PROJECT TITLE Harrington Four Plex

TYPE OF SUBMITTAL Grading Plan
(revised)

February 1, 1983

Re: Narrington Fourplex - 1721 Paisano
✓ (J22-D26)

- LEGEND**
- EXISTING CONTOURS.
 - SPOT ELEVATIONS.
 - PROPOSED PAVED AREA
 - T.O.W. TOP OF WALK.
 - F.F. FINISHED FLOOR.
 - FL. FLOW LINE.
 - F.G. FINISHED GRADE.
 - PROPERTY LINE, R.
 - T.B.M. TEMPORARY BENCH MARK.

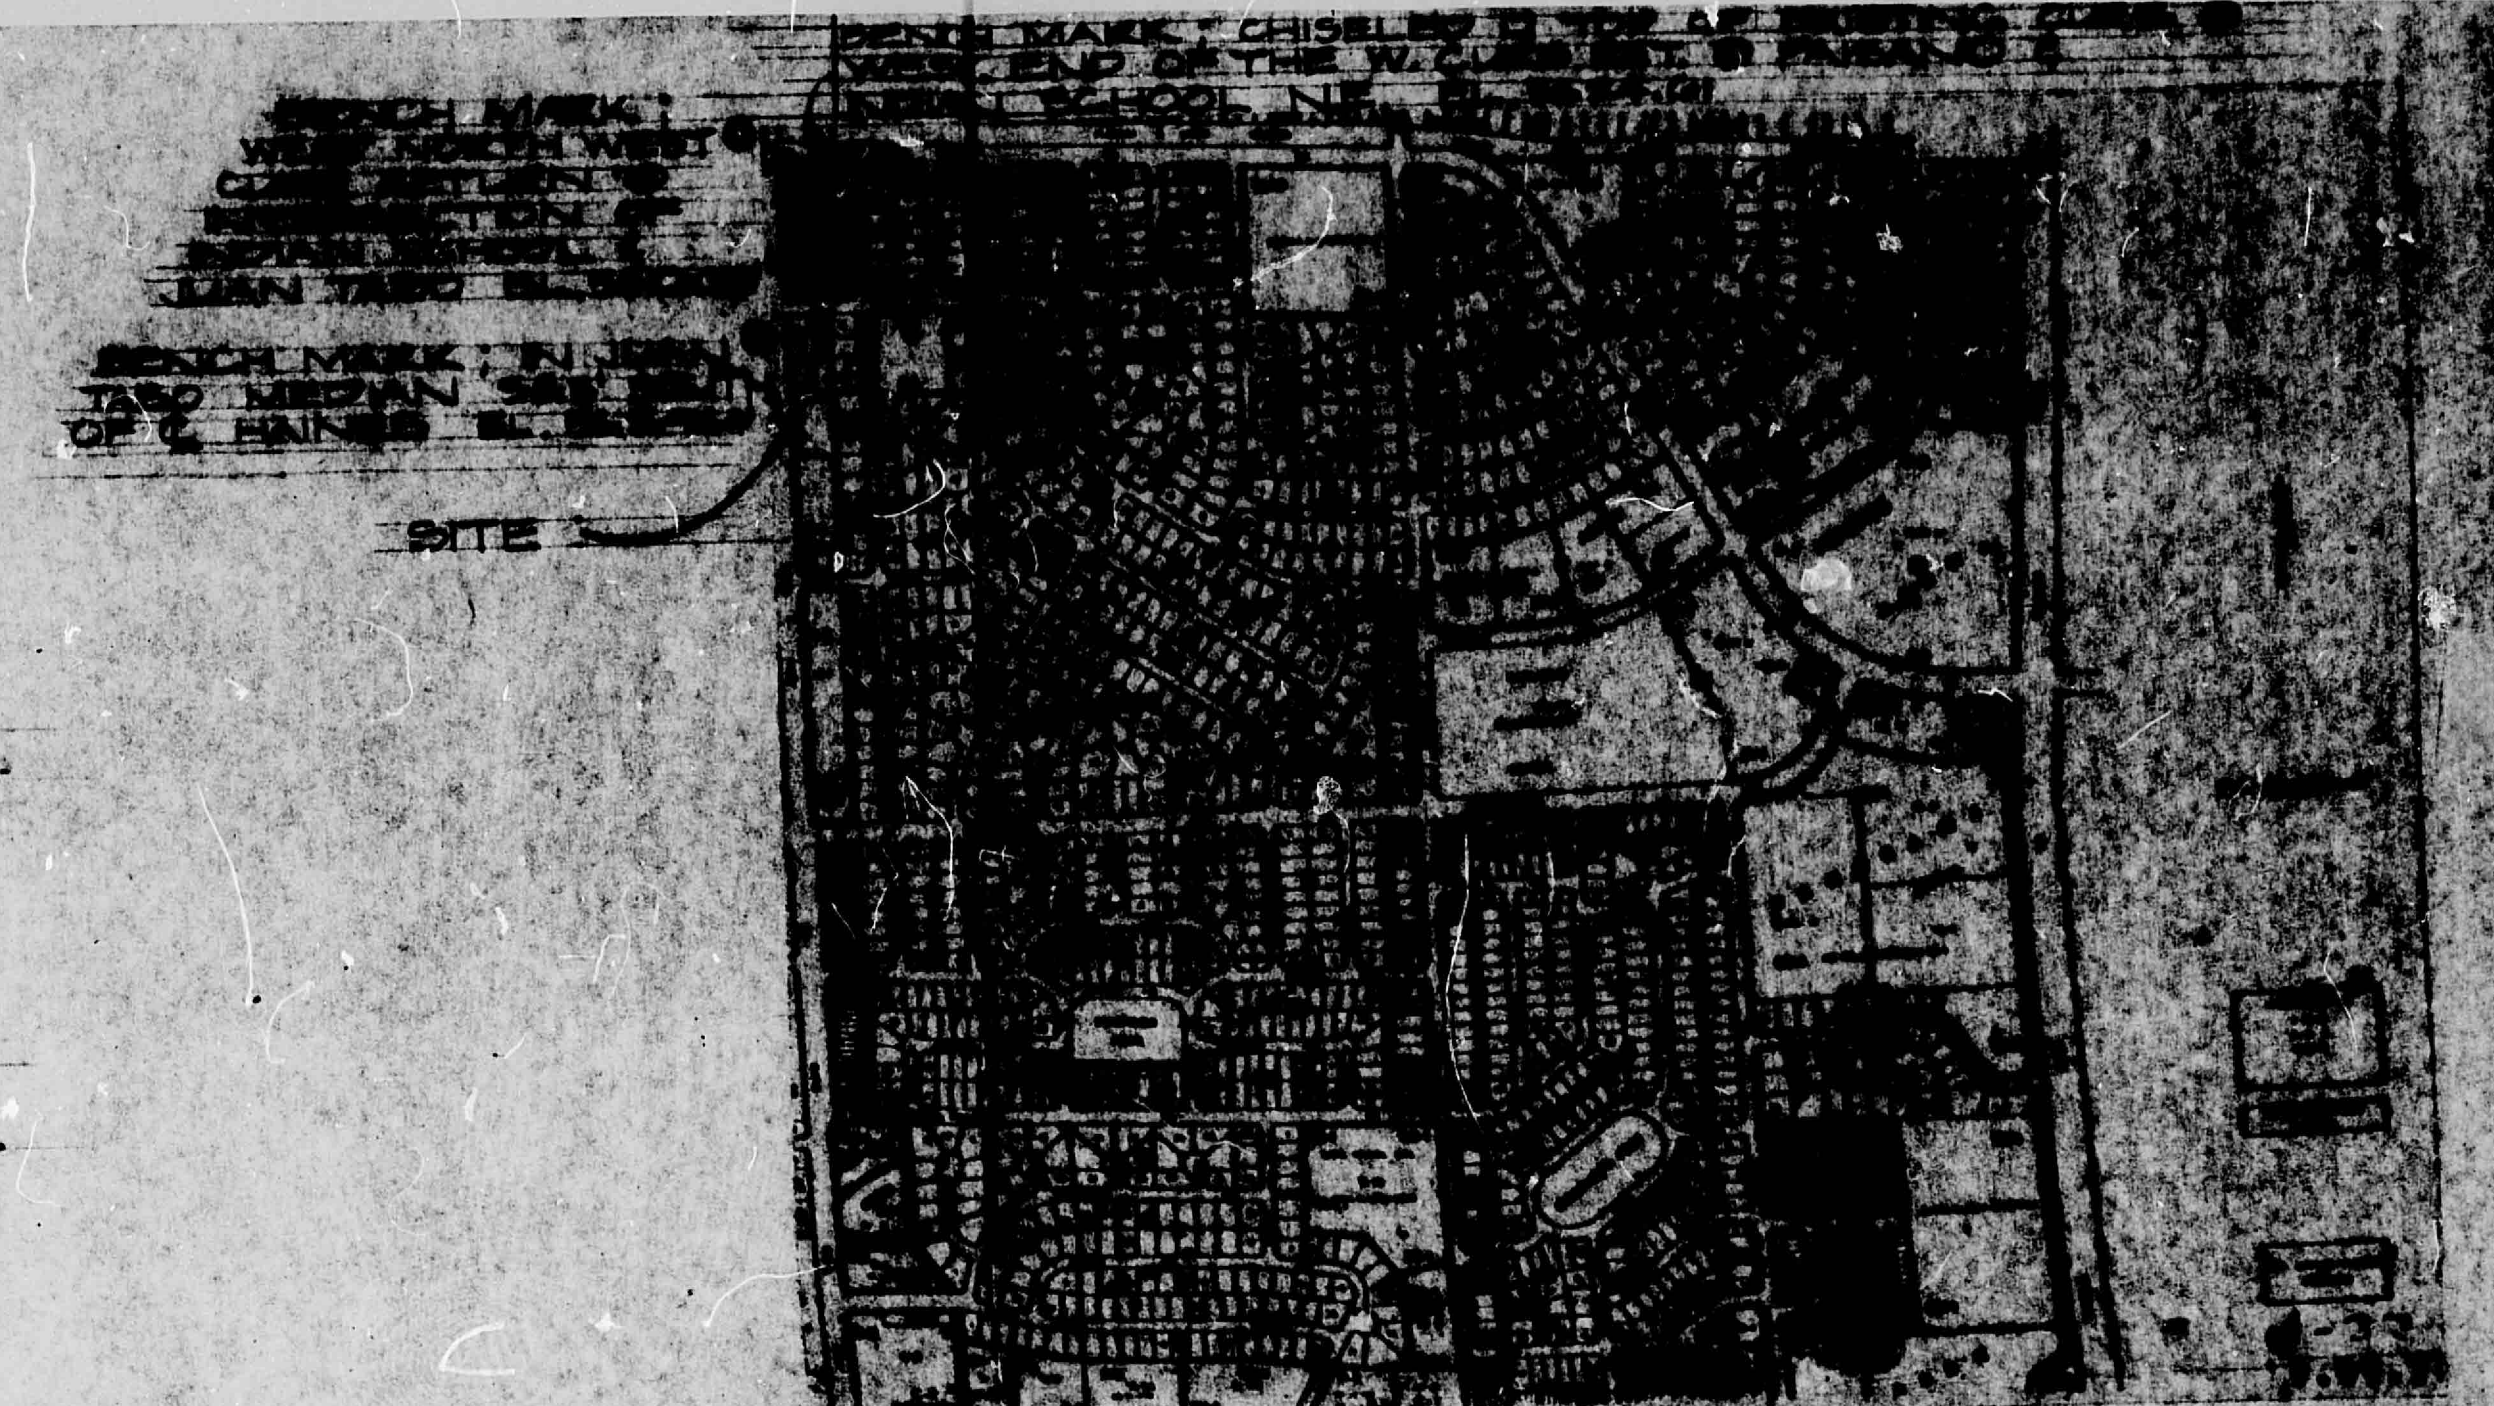
The drainage plan referenced above cannot be reviewed without the inclusion of the information below with your drainage plan. Provide this information with your resubmittal so that we can continue the review of the drainage plan.

1. City approved alley grades.
2. Sufficient grades supporting the proposed scheme to discharge the developed runoff to the City's right-of-way.
3. More flowline elevations within Paisano to determine the direction of flow.
4. Driveway elevations.
5. A comprehensive grading plan with the existing grades superimposed with the proposed elevations.

To the site plan we have incorporated the following changes

1. The finished floor elevation of the existing building to the south has been added.
2. The retaining wall section at the back property line has been revised to show that no new grading is taking place in the alley.
3. The property lines have been designated.
4. The developed site plan has been re-drawn to the proper scale.
5. A temporary bench mark has been indicated.

Also enclosed is a copy of the plan and profile sheet for Paisano Street. It indicates that flow past the site is northerly toward Indian School Rd. This development therefore will not worsen the flood hazard area at Lomas and Juan Tabo, which is south of the site.
